**PLANNING APPLICATION W/23/0145 ADDRESS: Woodside Conference Centre,
Glasshouse Lane, Kenilworth**
**PROPOSAL: Demolition of Existing Buildings and Erection of 55 Dwellings and
Associated Works**
Planning Officer: Dan Charles

Following receipt of your comments regarding the demolition of existing buildings and erection of 55 dwellings and associated works at Woodside Conference Centre, Kenilworth, dated 15 August 2023, please find below my responses.

TITLE
 Arboricultural Impact Plan

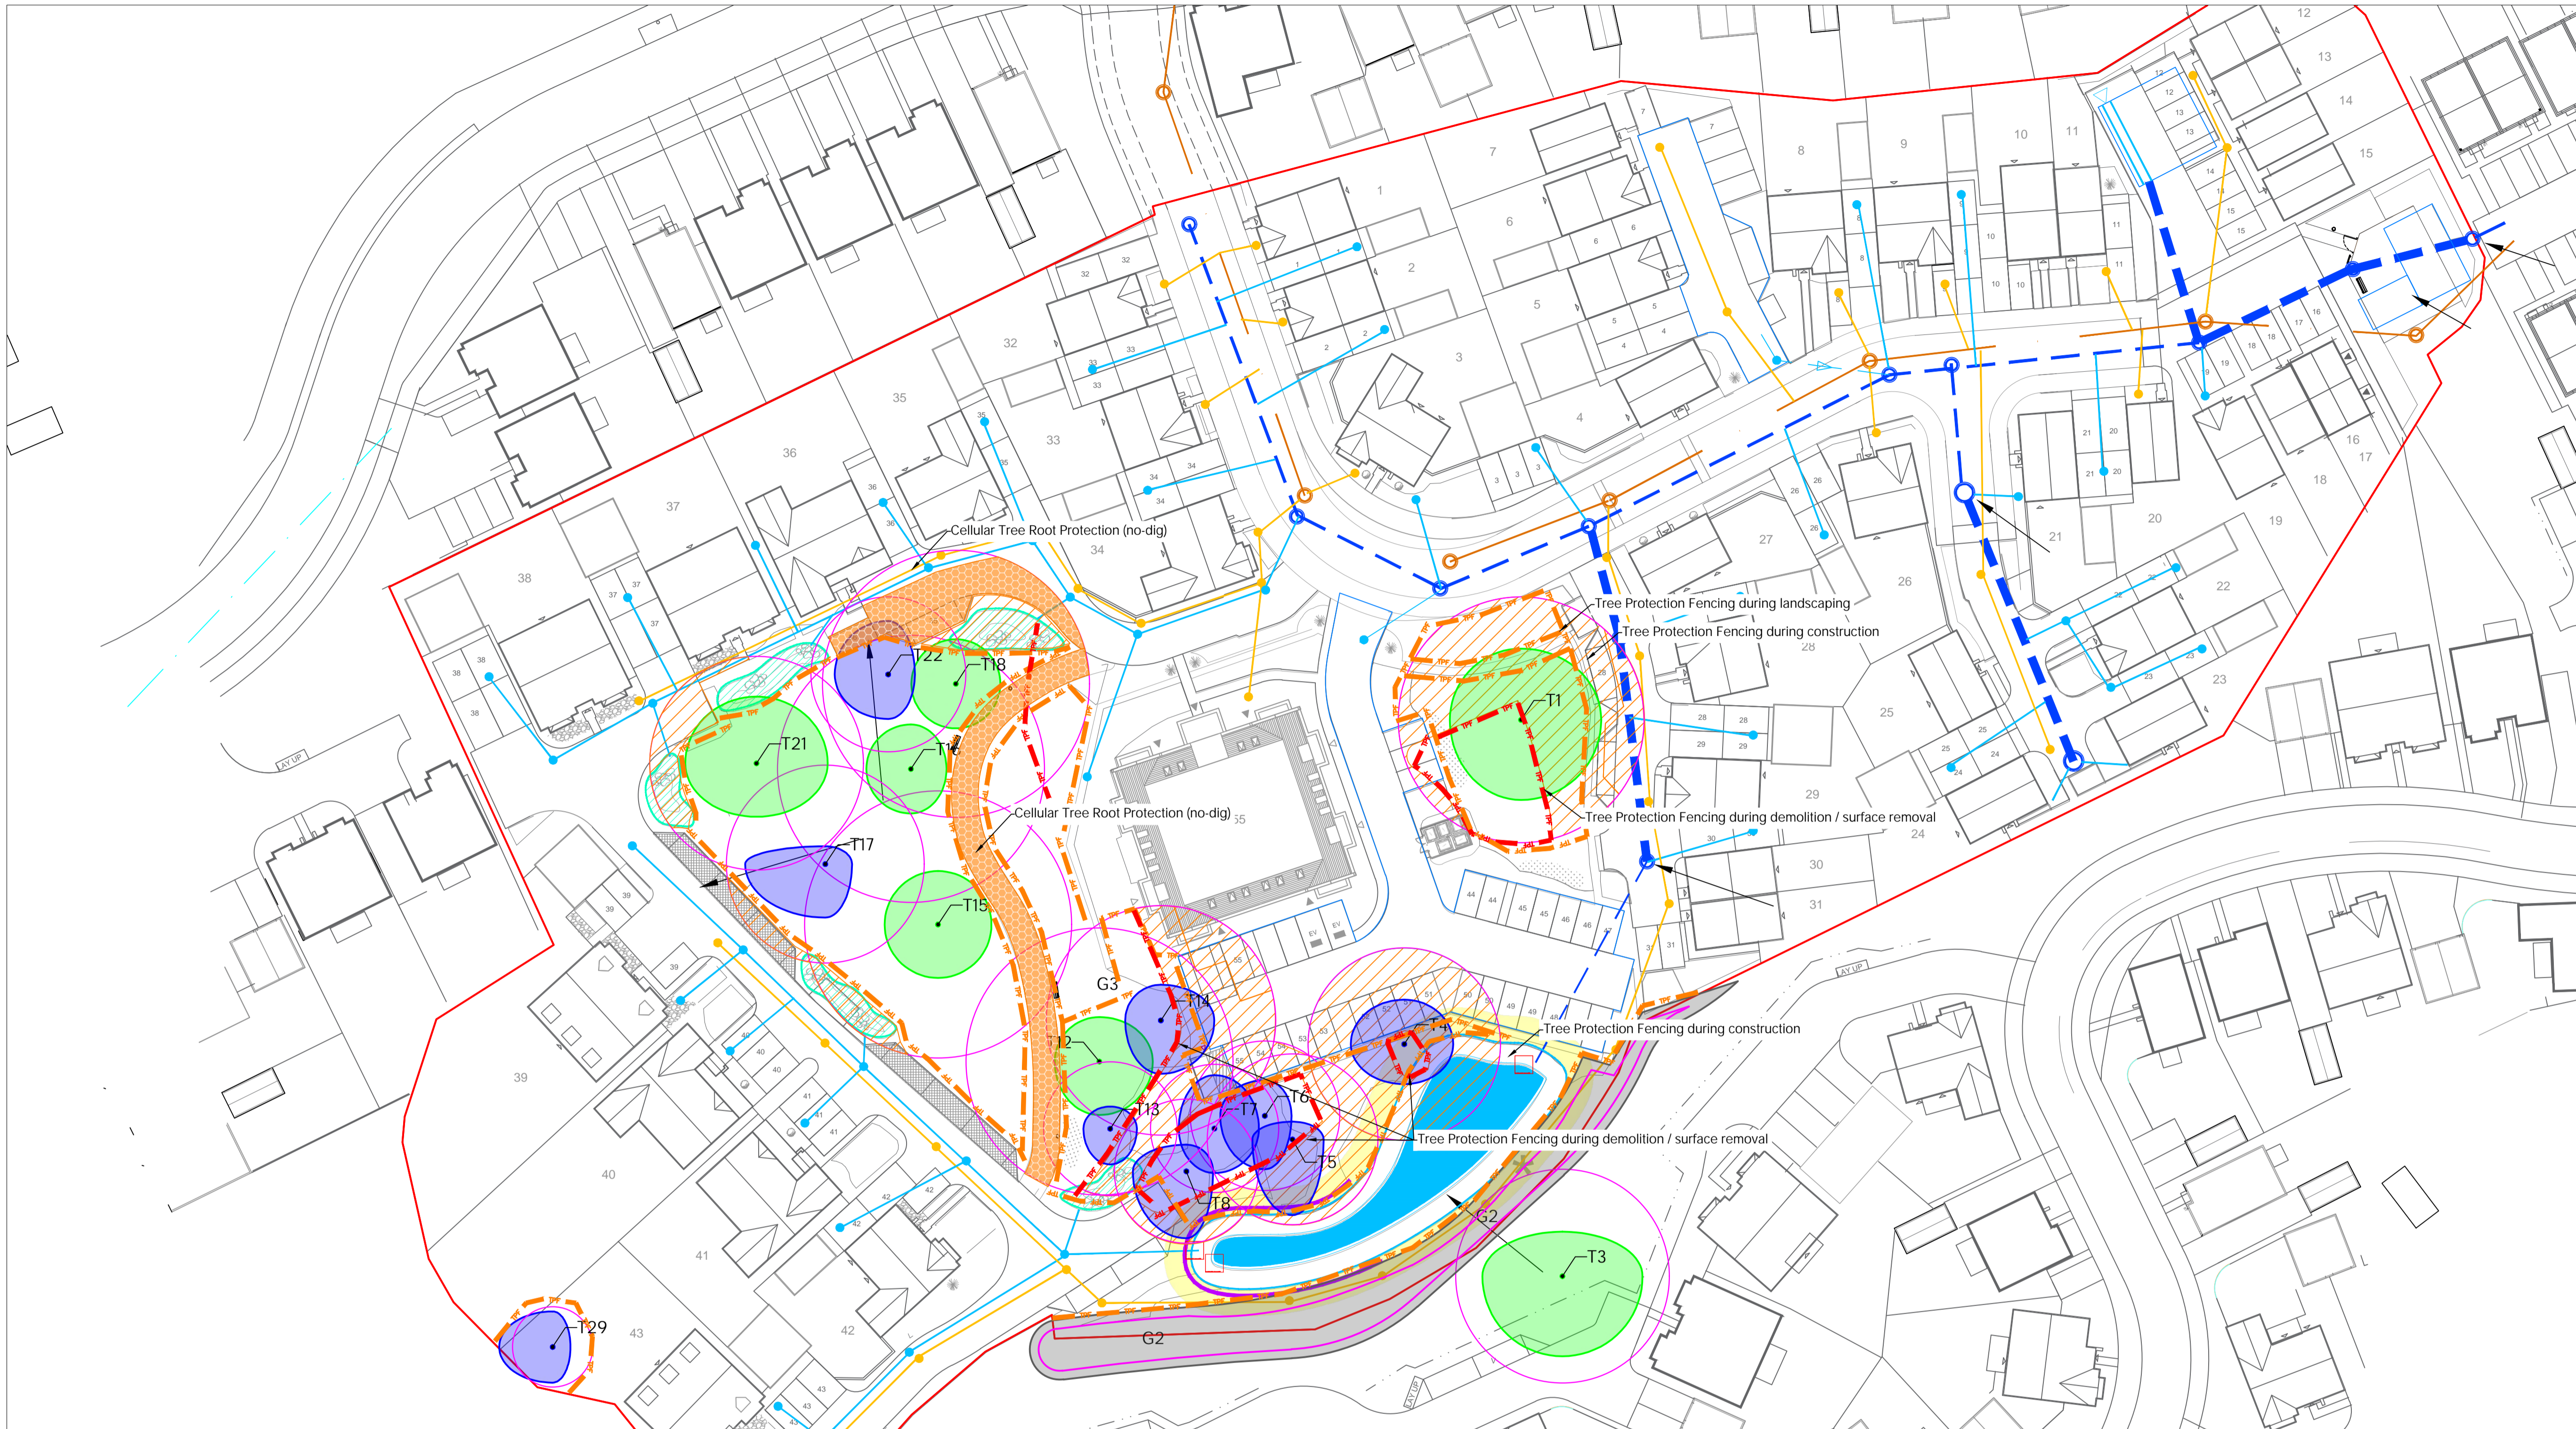
“The plan also shows the loss of the majority of the broad-leaved trees and proposes replacing them with a mix of ornamental and native ones. The proposals do give descriptions of the mature trees currently present on site, including an oak and two copper beeches which would be lost to the development as proposed, but it would be useful to have at least the mature trees labelled individually on the plan. As with the existing waterbody & surrounding scrub, retaining existing broad-leaved trees wherever possible is preferable in ecological terms, as they are already established, and native species support a wide range of associated fauna – including invertebrates, which ornamental ones do not. In addition, many of our native tree & shrub species are very attractive.”

The proposed tree losses are shown within the AMS produced by Seed (reference: 1400-AMS-V1-B), which details that the species proposed for removal include mainly non-native species owing to the ornamental nature of the site, which was previously a garden. Species proposed for removal include turkey oak, sycamore, copper beech, western hemlock, cypress sp., Douglas fir, western red cedar, cockspur hawthorn, cherry laurel, Portuguese laurel and rhododendron. All of the ash trees and one wild cherry proposed for removal are Category U and would therefore require removal regardless of the development. The exception to this being the loss of four wild cherry trees; however, the proposed planting scheme includes six cherry trees for planting.
